**Anglian Water Services Ltd**

**Tilbury 2: Non-statutory consultation**

Tilbury 2 Project

Drawing Title: **SCOPING REPORT  
GENERAL ARRANGEMENT  
SHEET 1 OF 2**

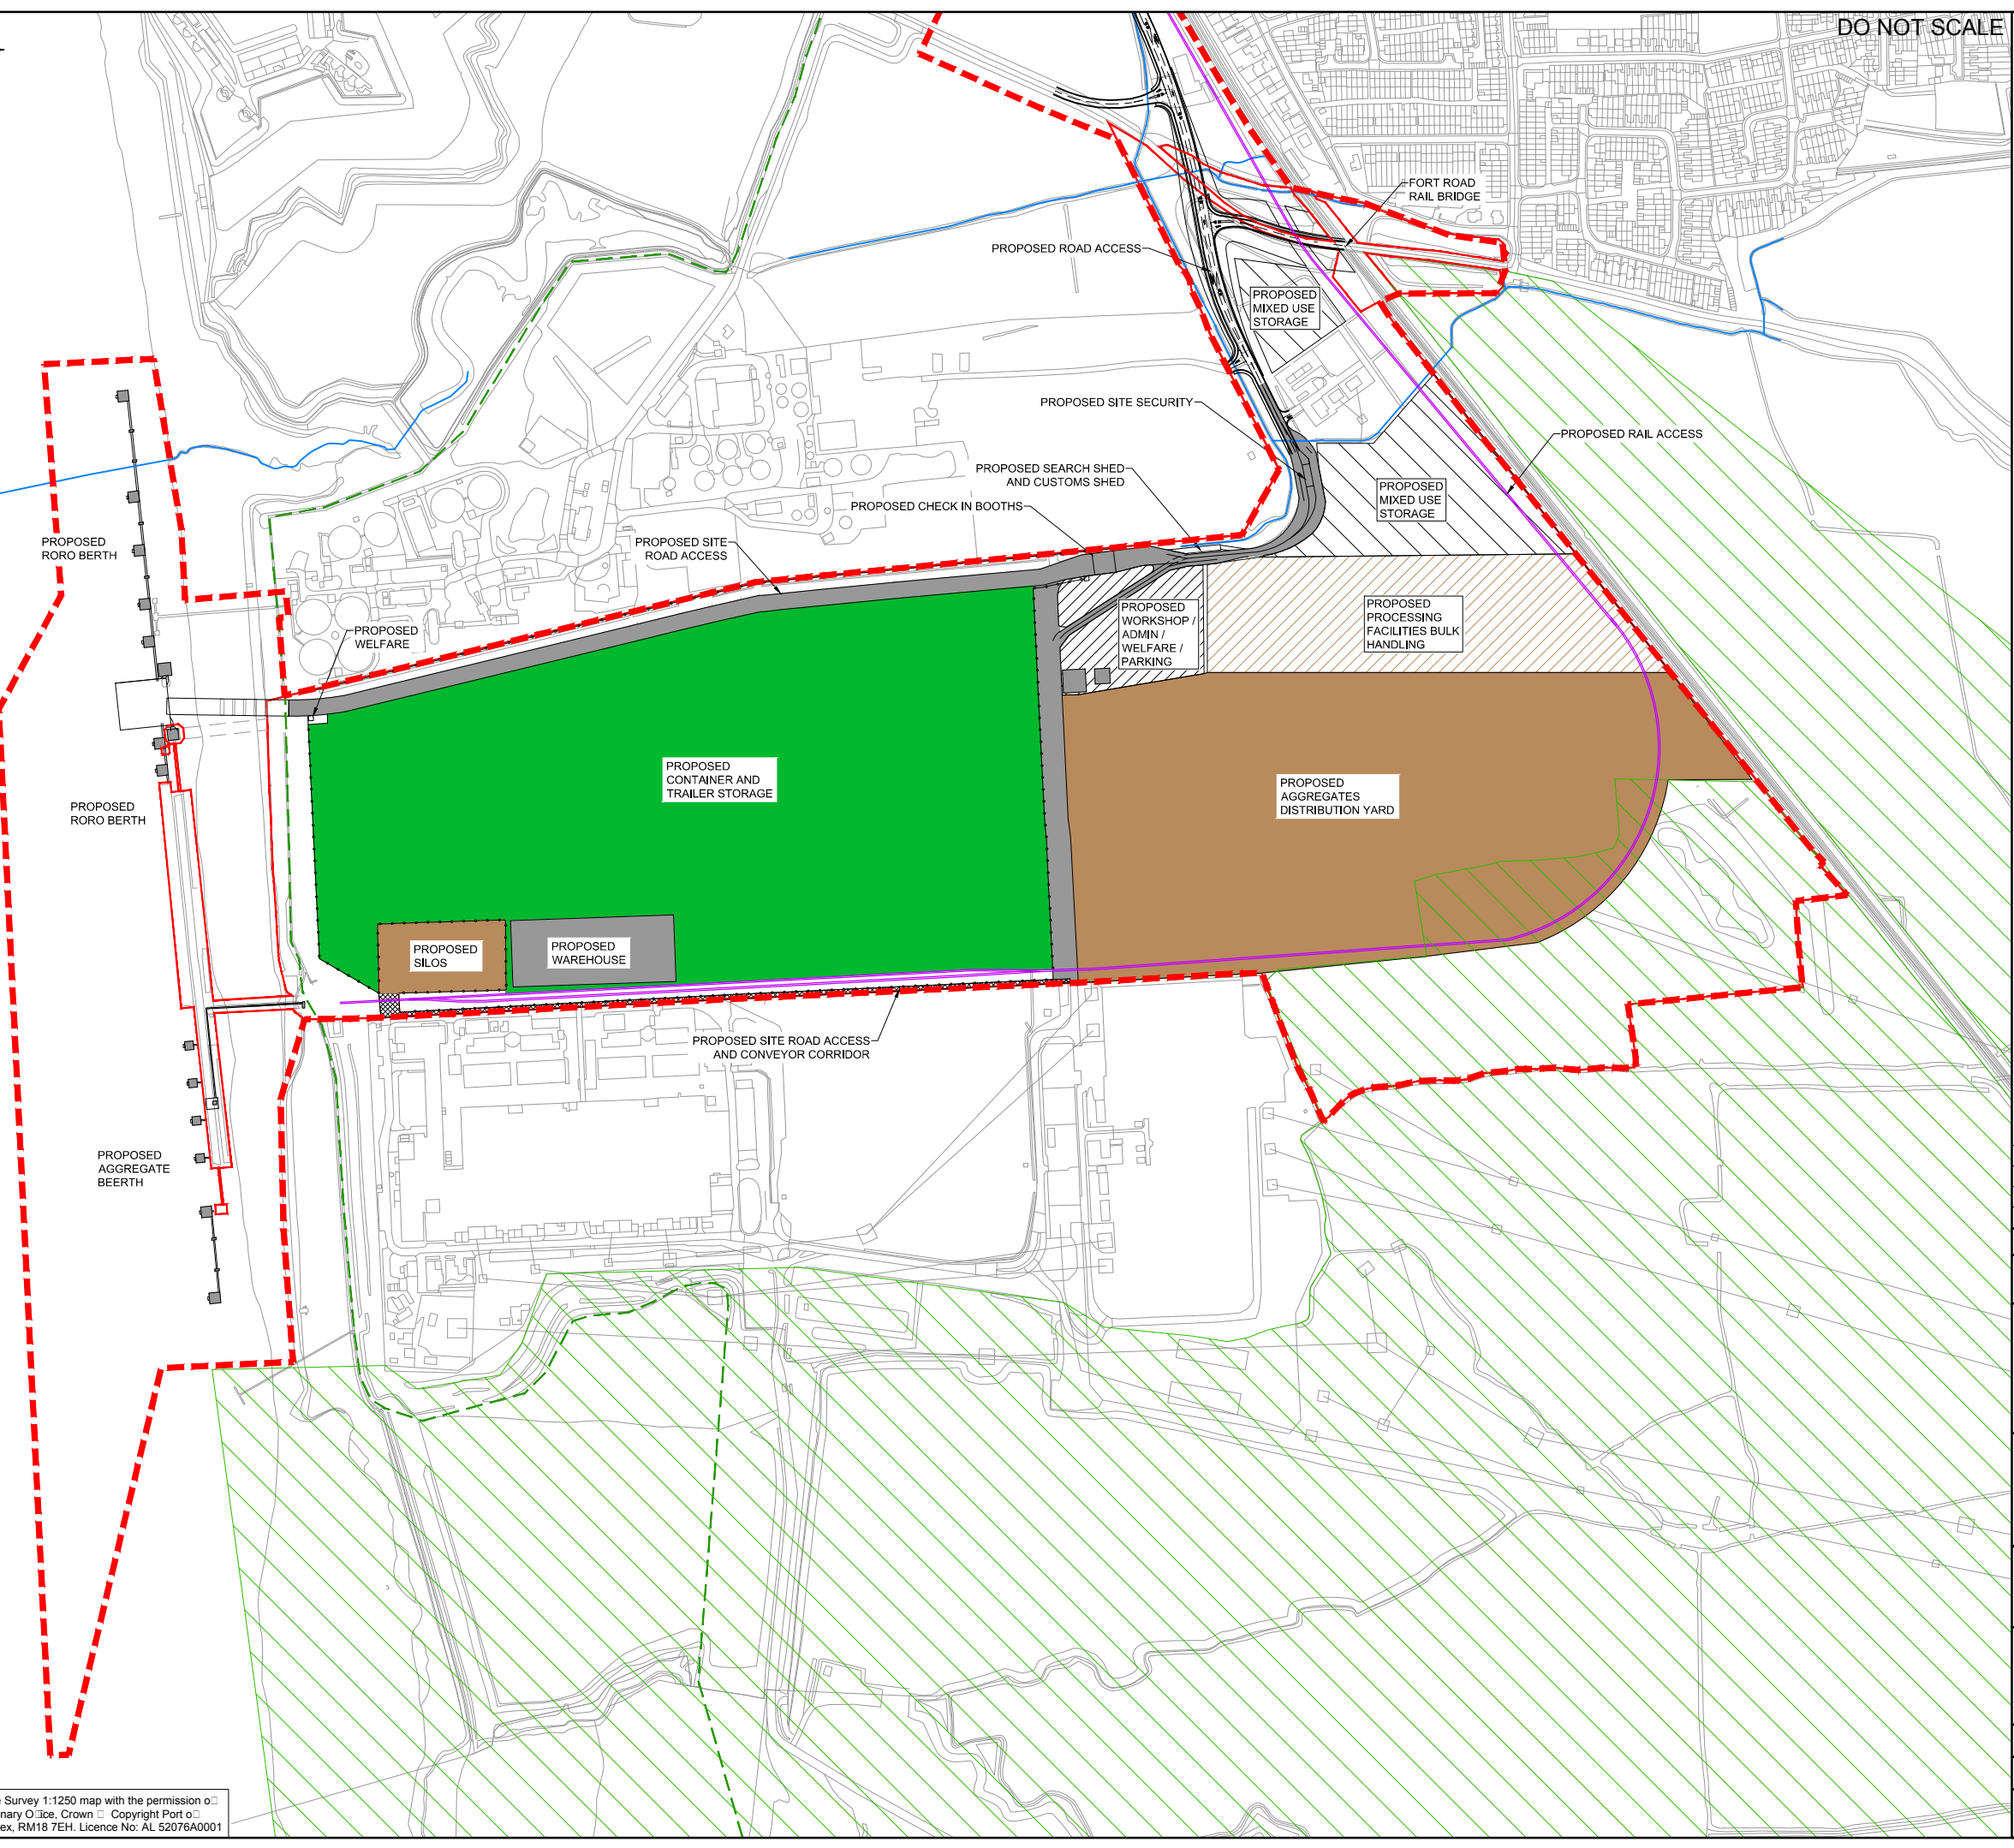
Views are sought on the location of the proposed road link as illustrated on the exhibition boards. It is important to note that there are a number of existing foul sewers located within the area identified as construction materials terminal and potential new road and rail links.

If it is not possible to incorporate existing sewers as part of the site layout there may be a need to divert these asset(s). We have a duty to divert existing sewers where requested to do so although it would be at the applicant's expense.
